DESIGN PROFESSIONAL INSPECTION FORM

REPORT OF OBSERVATION AND EVALUATION

Address: VANERT RESIDENCE
536 LAKESIDE LN
SANFORD, NC

I OBSERVED CONSTRUCTION OF GARAGE ADDITION ON THIS DATE.

Job 20020021-J	Truss A01	Truss Type Common Supported Gable	Qty 15	Ply 1	quotes-Chuck Smith Job Reference (optional)
-------------------	--------------	--------------------------------------	-----------	----------	--

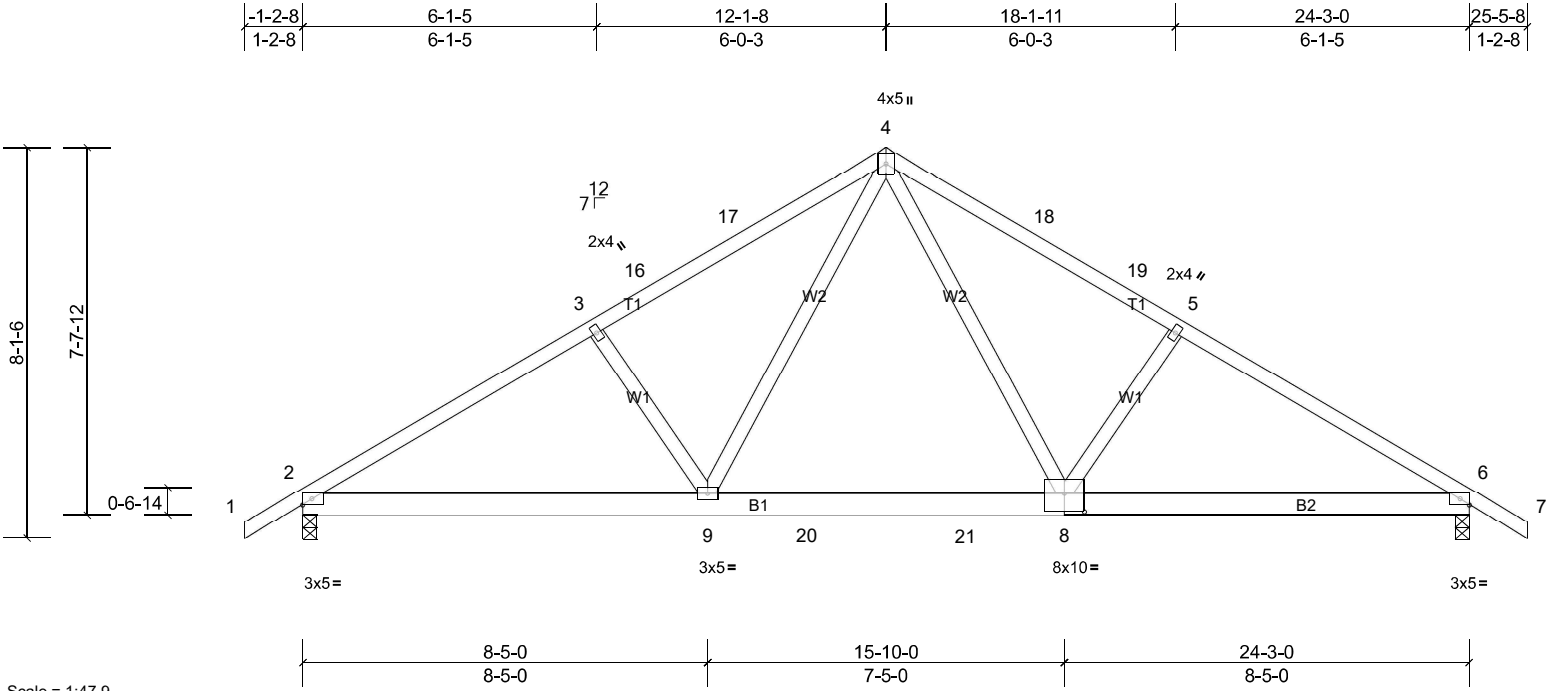
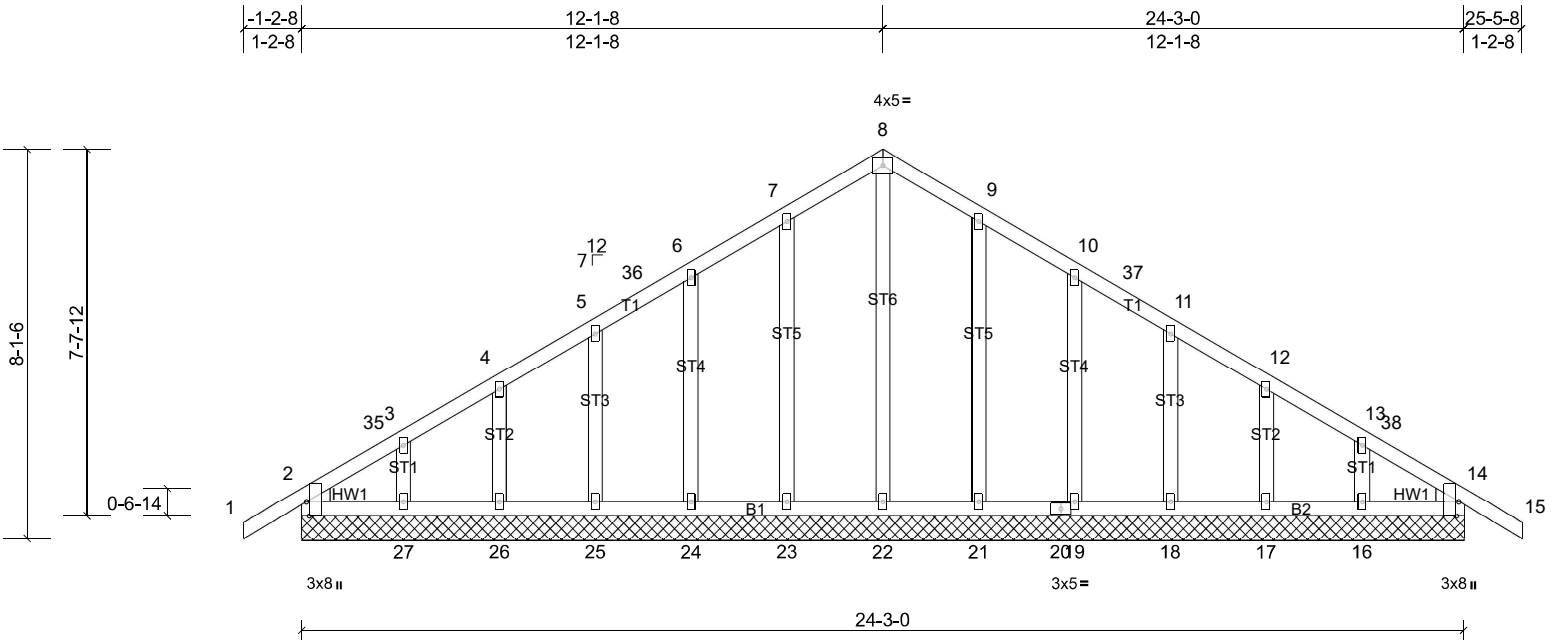
1. GABLE TRUSS BEARING ADEQUATE.
2. REMOVE/REPLACE BRICK MOUNTS AS SHOWN IN DETAIL B.
3. INSTALL DOUBLE TOP PL AND HEADER AT WINDOWS AS SHOWN IN DETAIL A.
4. ADD STRAP TO POST AS SHOWN IN DETAIL C.
5. ADD 2 LINES OF BRACING @ BOTTOM CHORD OF ROOF TRUSSES AS SHOWN BELOW
6. FOOTING PROJECTION / DEPTH ADEQUATE.
